Recommendation Report for Planning Permission for Works or Extension to a Dwelling

REF NO: M/15/19/HH

LOCATION: 1 Tudor Close
Middleton-On-Sea
PO22 6DN

PROPOSAL: Two storey side/ front extension

Proposed First Floor Plan

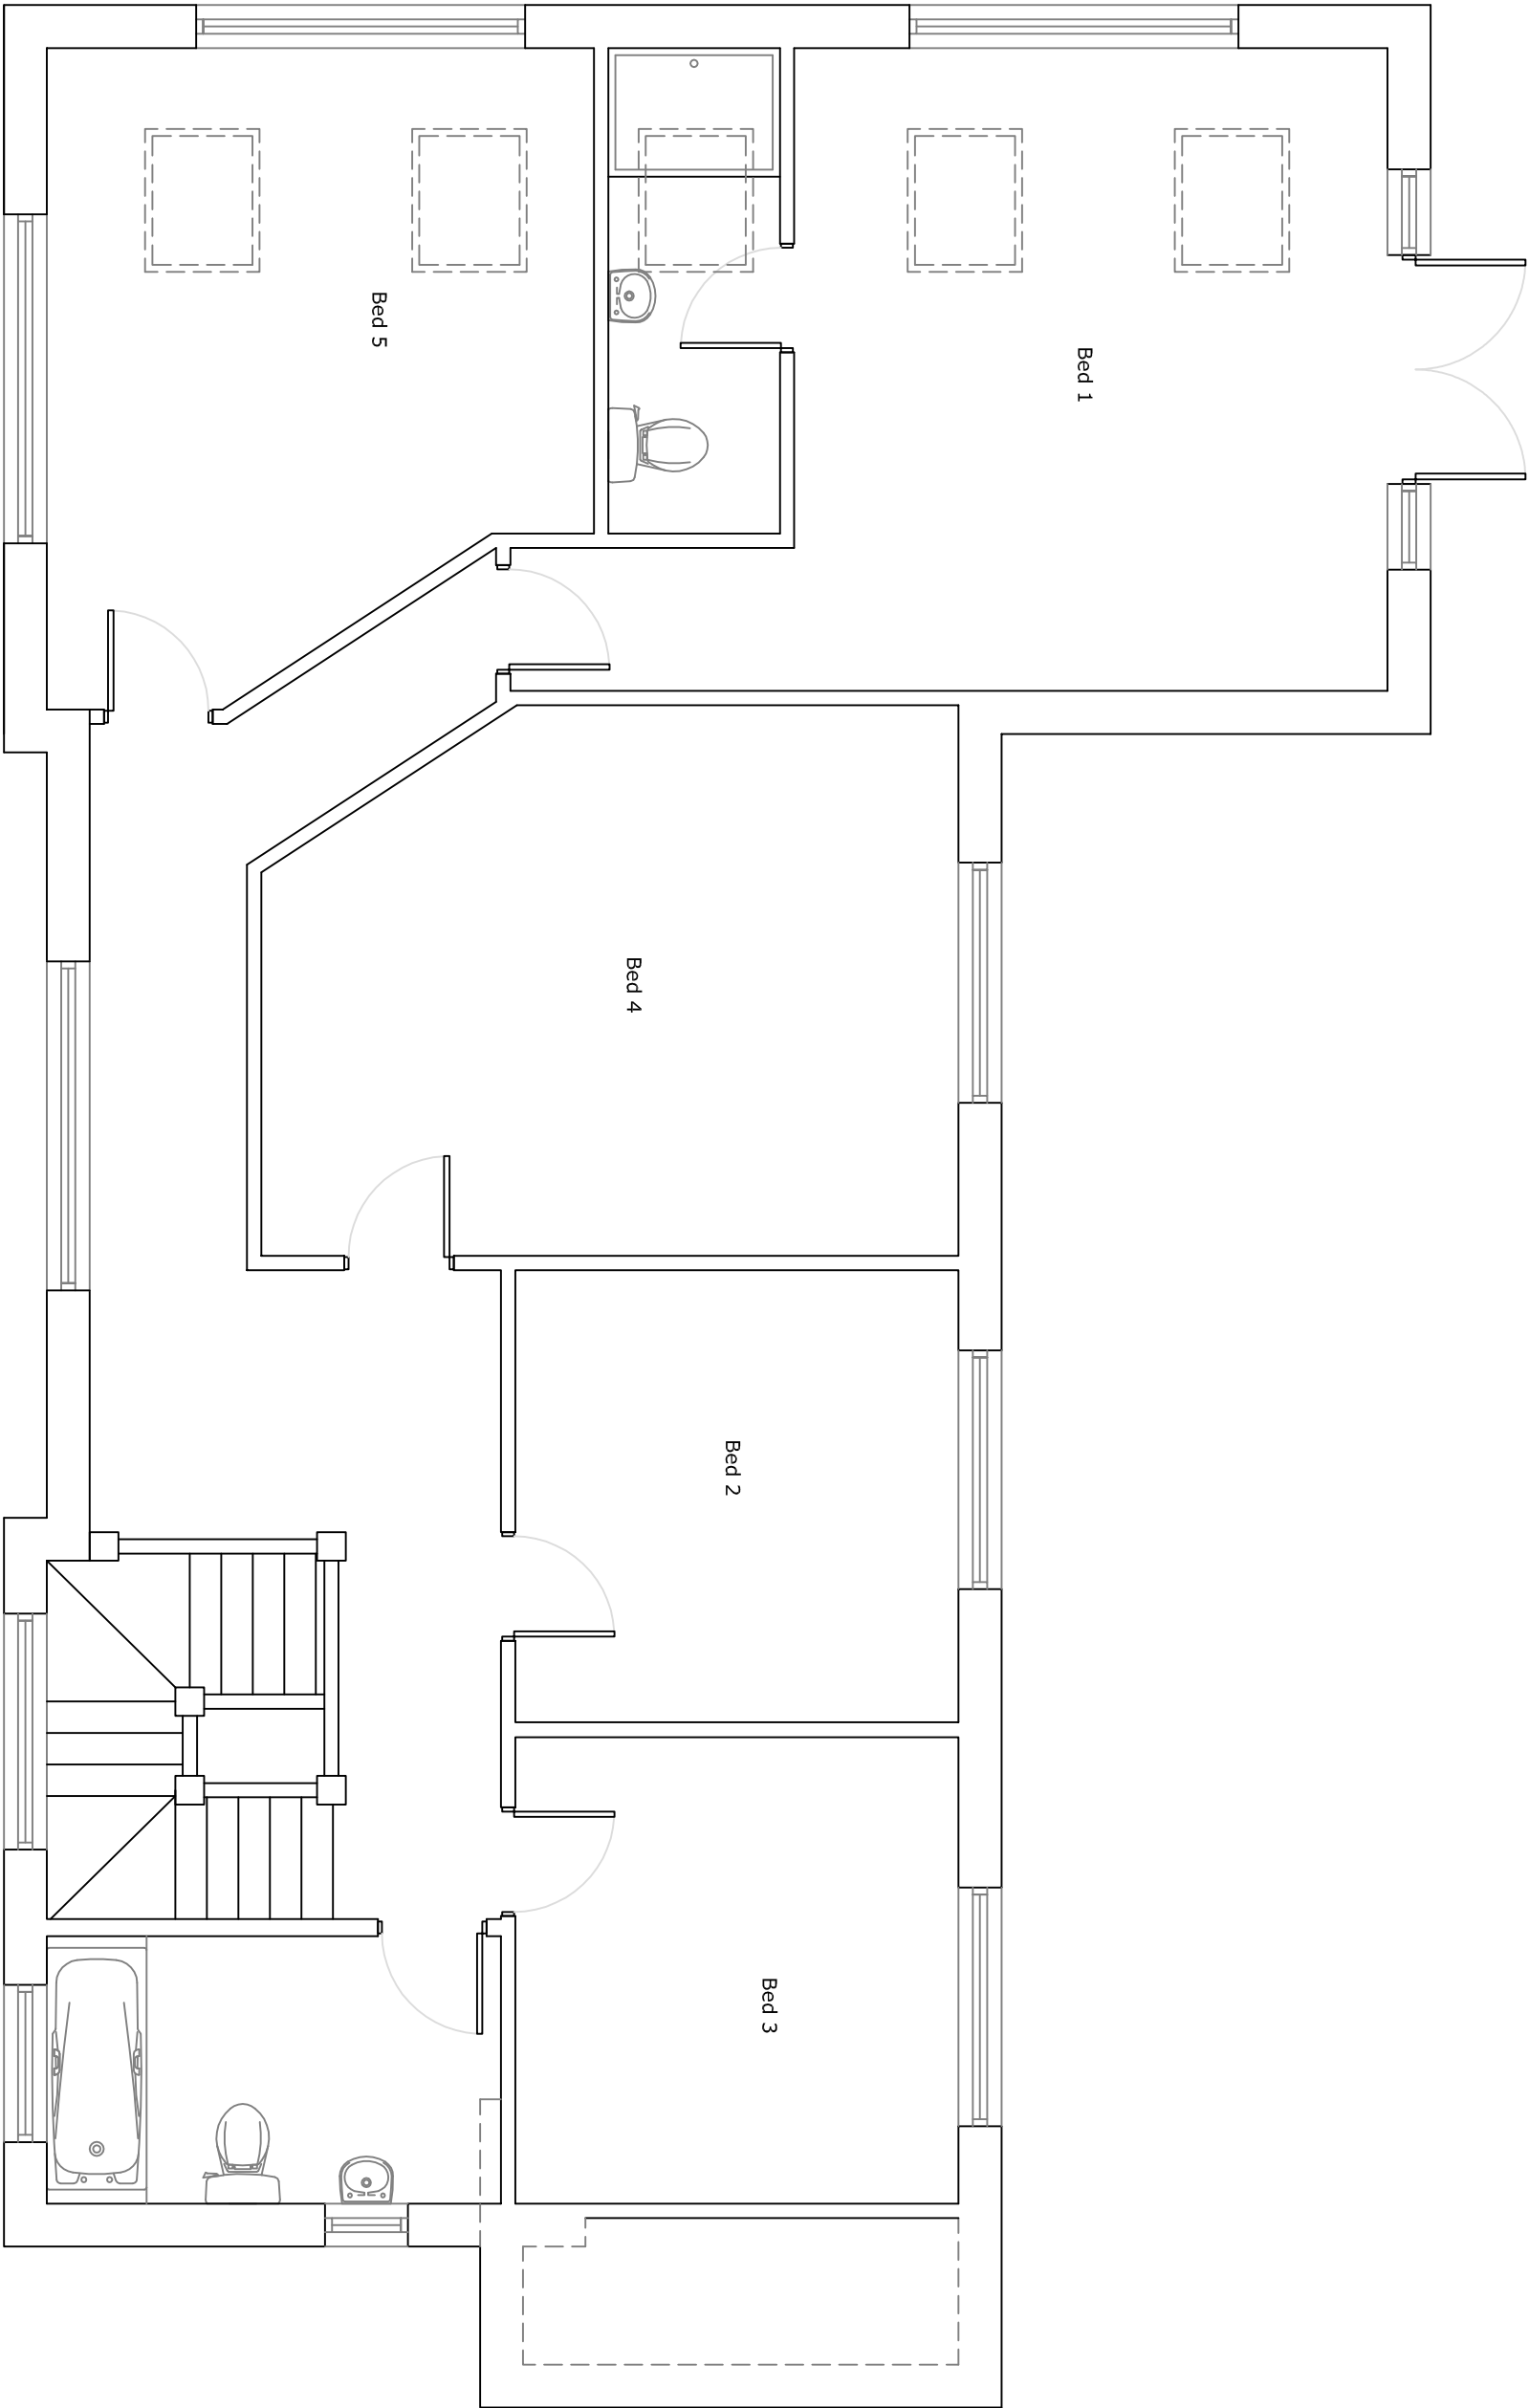
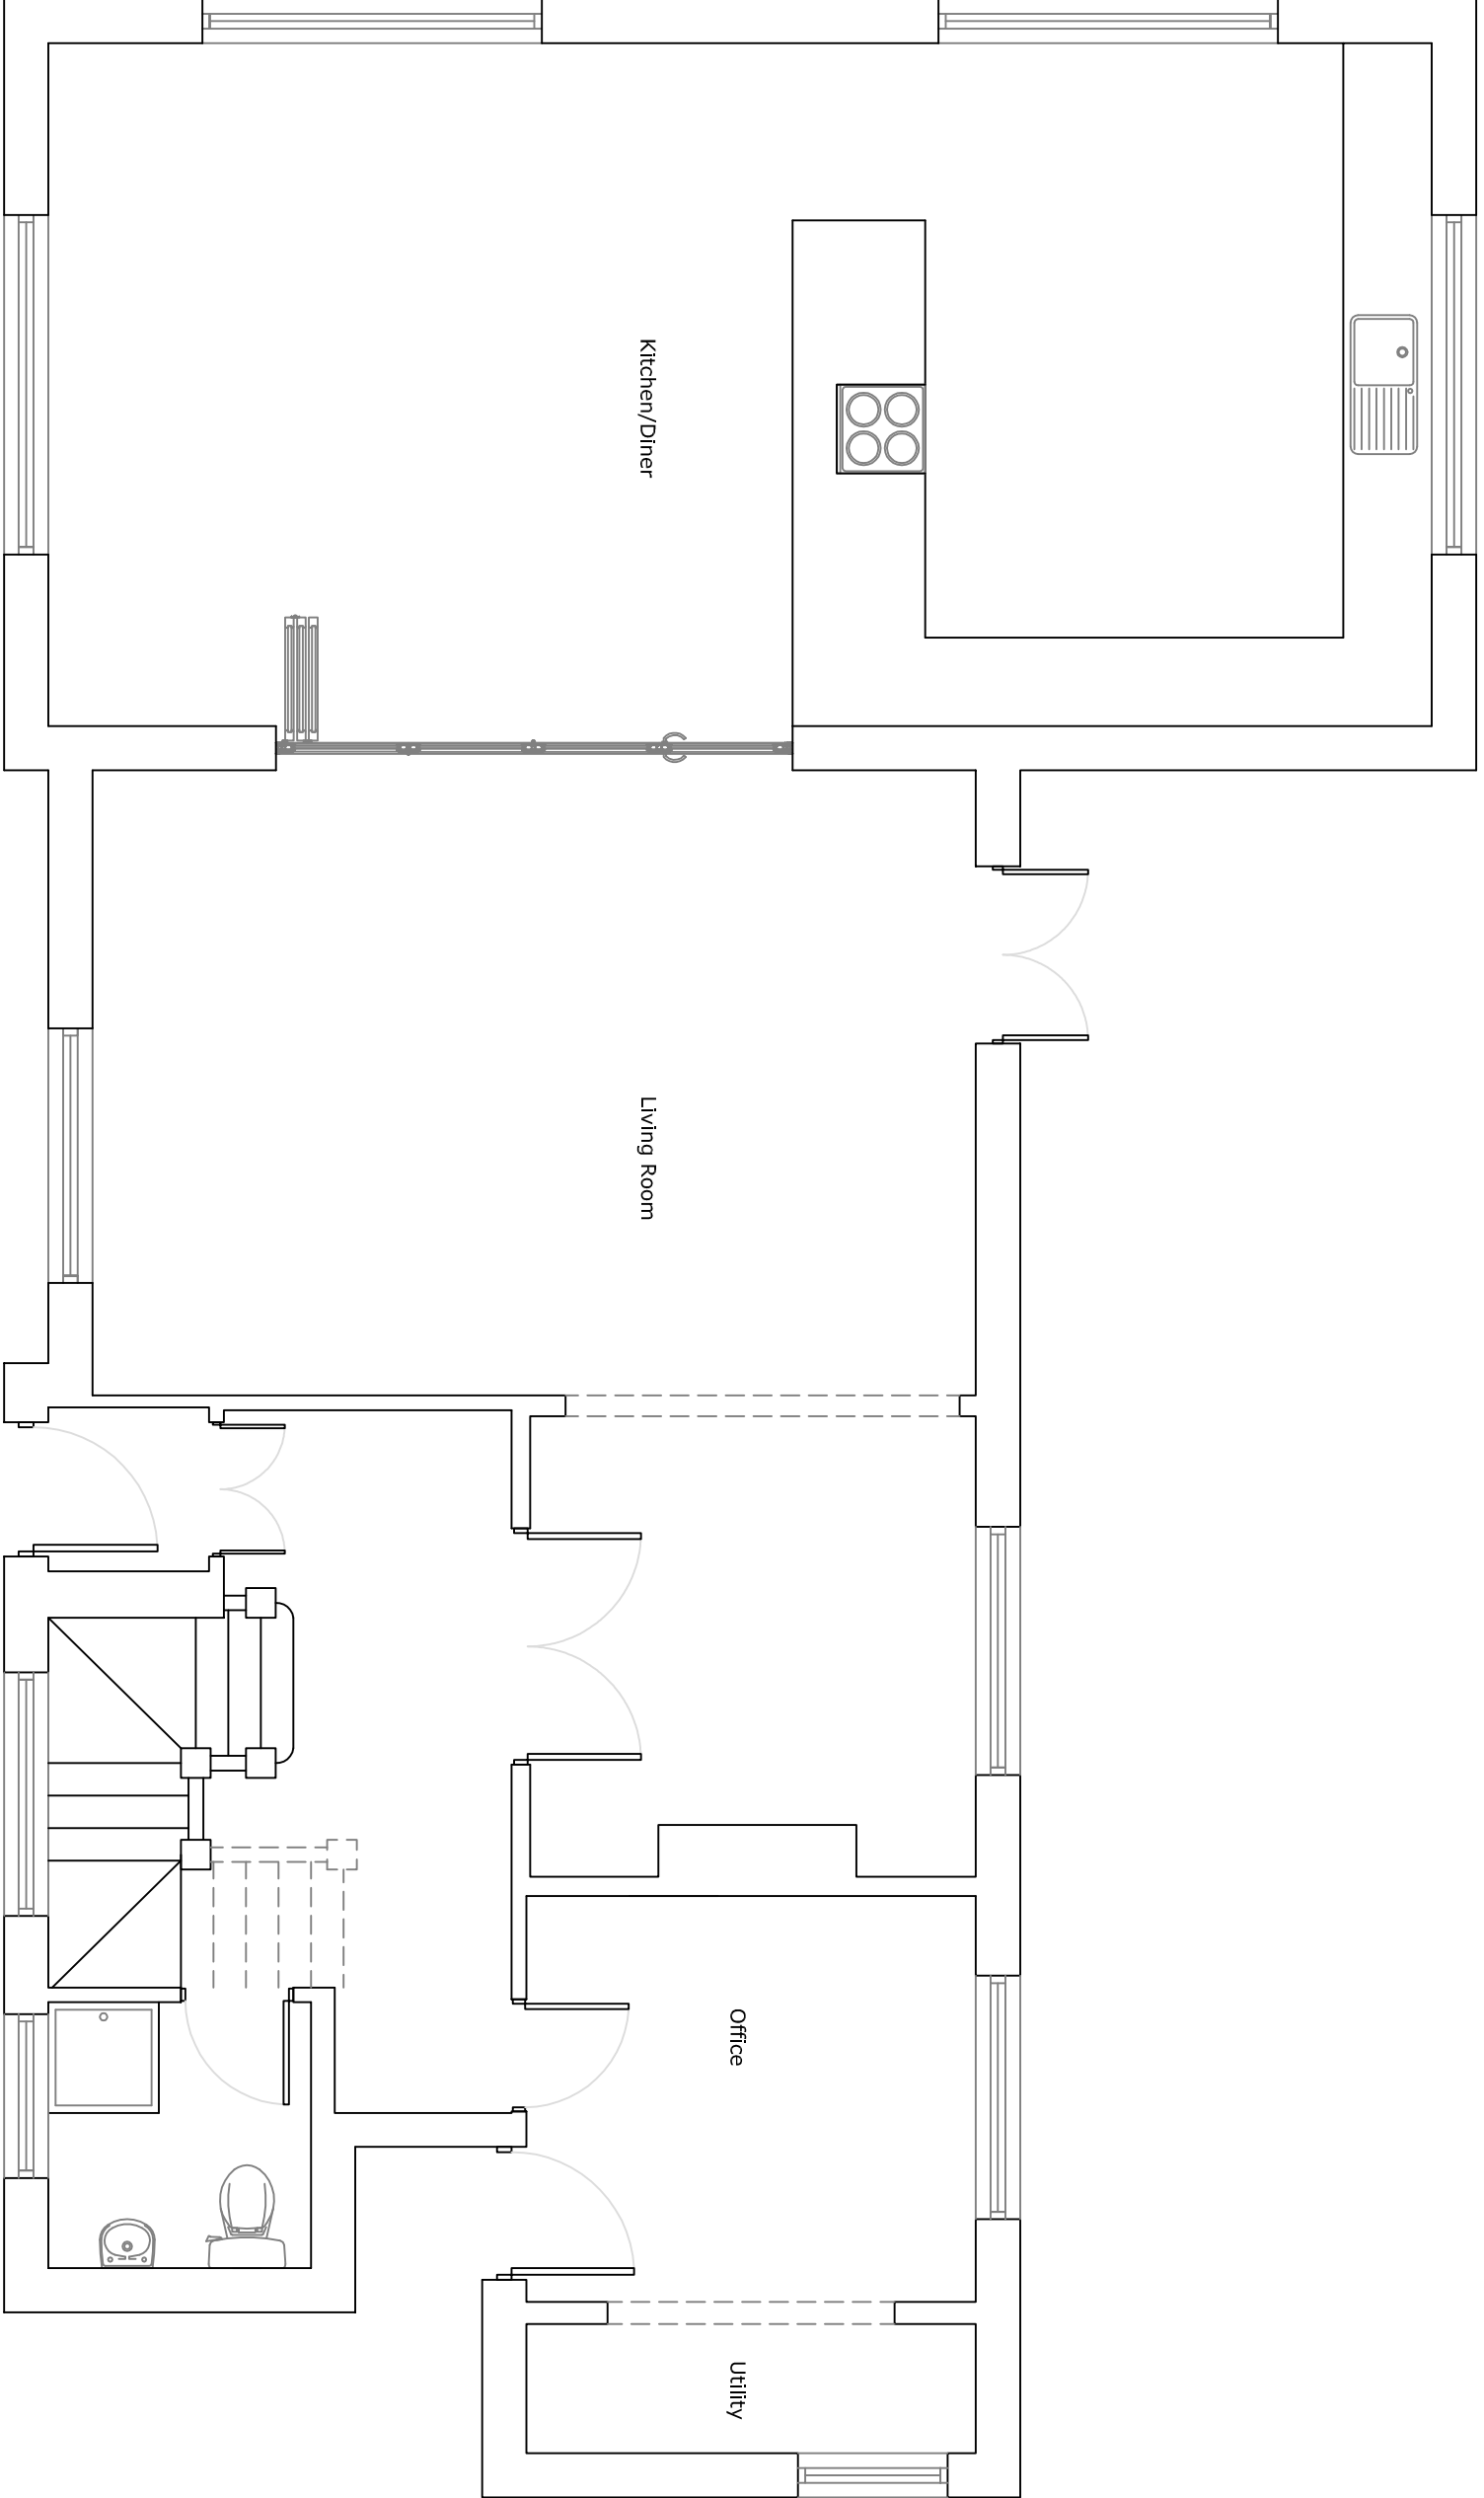
The proposed development represents a significant change to the appearance of the host dwelling, as a result of its significant scale, and siting. The proposed development is not considered to be a subservient addition to the host dwelling, as it matches the ridge height of the host dwelling, and constitutes an increase of 64% to the footprint of the host dwelling, as it adds 44.06sq.m. of floor area to the host dwelling, which is 68.4sq.m. Therefore, the proposed development is not considered to be in accordance with D DM4(b) of the Arun Local Plan. Whilst it is considered that the proposed development is not visually subservient to the host dwelling, it should be noted that as a result of the size of the residential plot, the proposed development is considered to respond well to the scale of the plot, and is subservient when compared to the size of the residential plot, therefore is not considered to compromise overdevelopment of the residential plot.

As a result of the design of the proposed extension, it is considered to appear well integrated with the host dwelling, resultant of its siting, design and use of materials. The design of the proposal and the matching materials allow the extension to have no significantly harmful impact upon the character of the host dwelling, as it is considered to resonate with it, in terms of character and appearance. This is helped by the design of the roof being of a similar design to the existing Eastern projection of the host dwelling. Additionally, as a result of the boundary treatment, there are very few available views of the proposed development from the street scene, which is considered to allow the proposed development to have no significantly harmful impact upon the character of the locality. There will be some views of the Southern aspect of the roof of the proposal, it will be conditioned that roof light details are confirmed, in order to ensure that they are of an acceptable design.

Therefore, whilst the proposed development is considered to be in conflict with D DM4(b) of the Arun Local Plan, it is in accordance with D DM1, D DM4(a) and (e) of the Arun Local Plan.
